**Terry Daly
22/255 Avoca St
Randwick 2031**

9 March 2011

**Re: Environmental Assessment for Prince of Wales Mental Health Intensive
Care Unit Randwick MP10_0131**

AR\_MHICU\_DA\_01 02

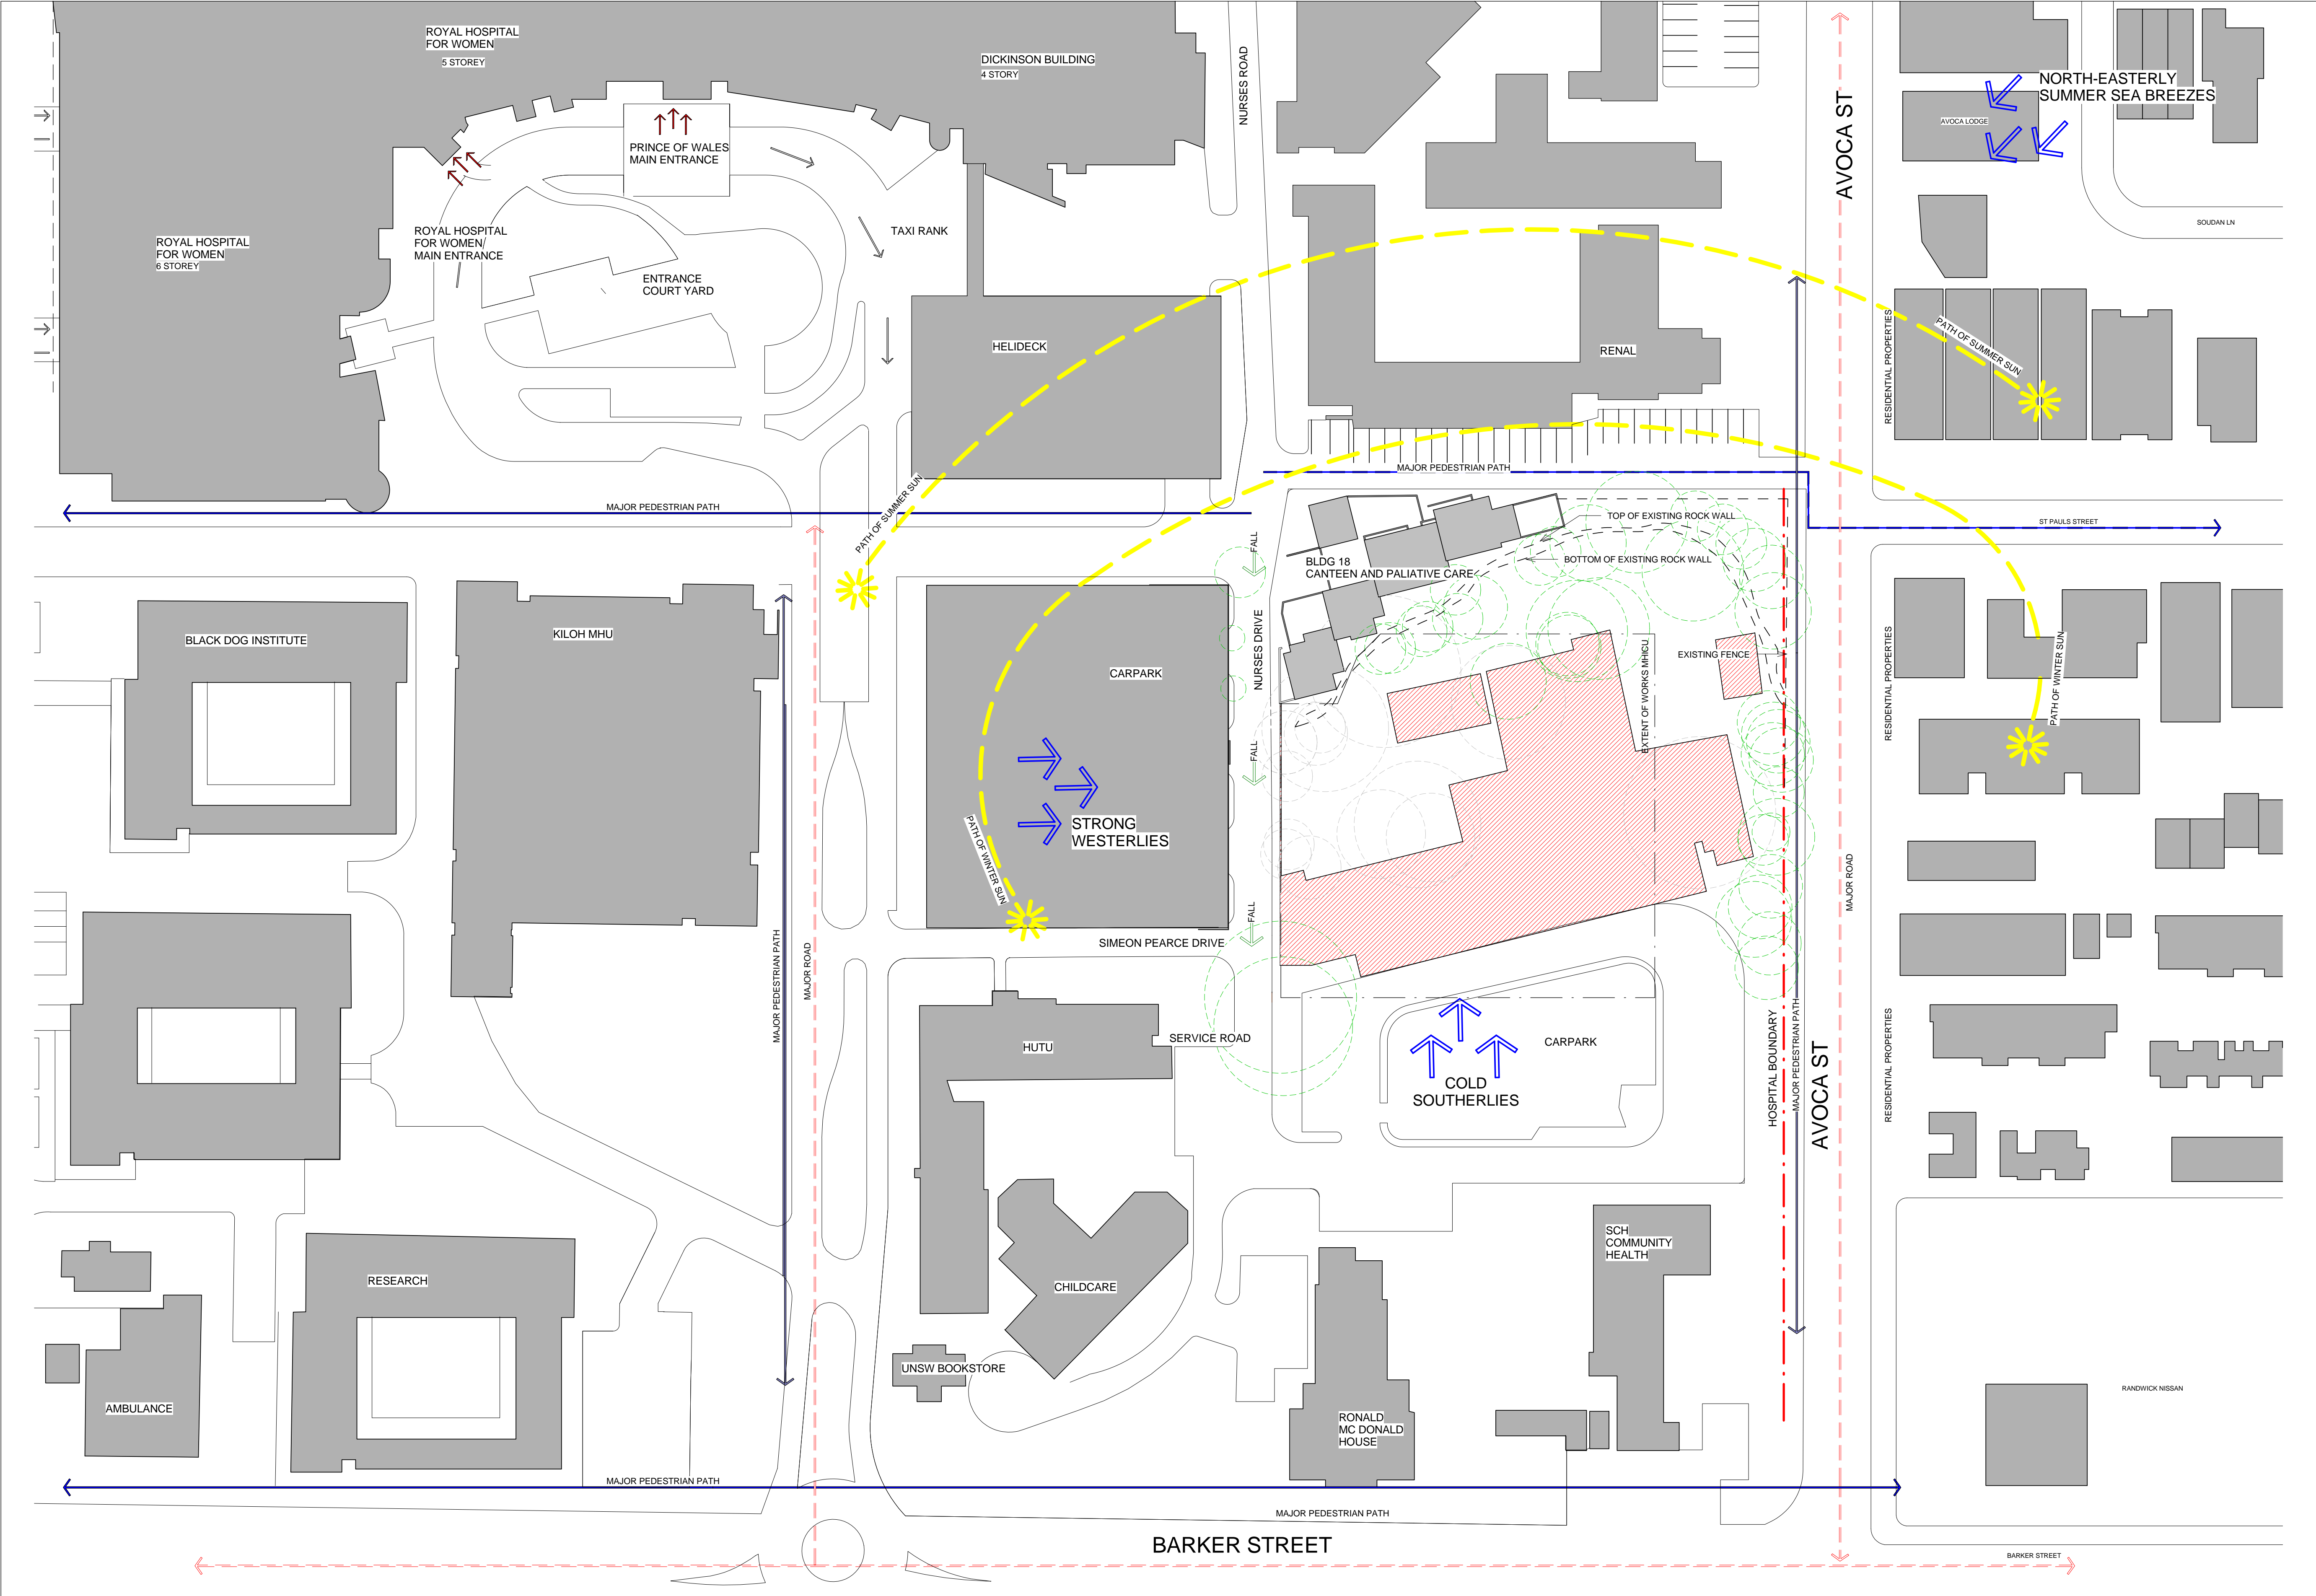
It is simply unjustifiable to remove the majority of the tree cover. This is particularly true when considering the amount of space available to the development, and that a different orientation would save many of these trees. The footprint is smaller than the previous building that co-existed with these trees. In addition, the demolition of the previous multi story building was undertaken while protecting these trees.

In particular the proposed removal of trees numbered 20 and 21 which are both in excess of 25m, and the trees numbered 3,6, and 7 which have been classified by the Aboricultural Impact Assessment as having the highest level of both scale

and retention vale. Despite this assessment, each of these trees is marked for removal.
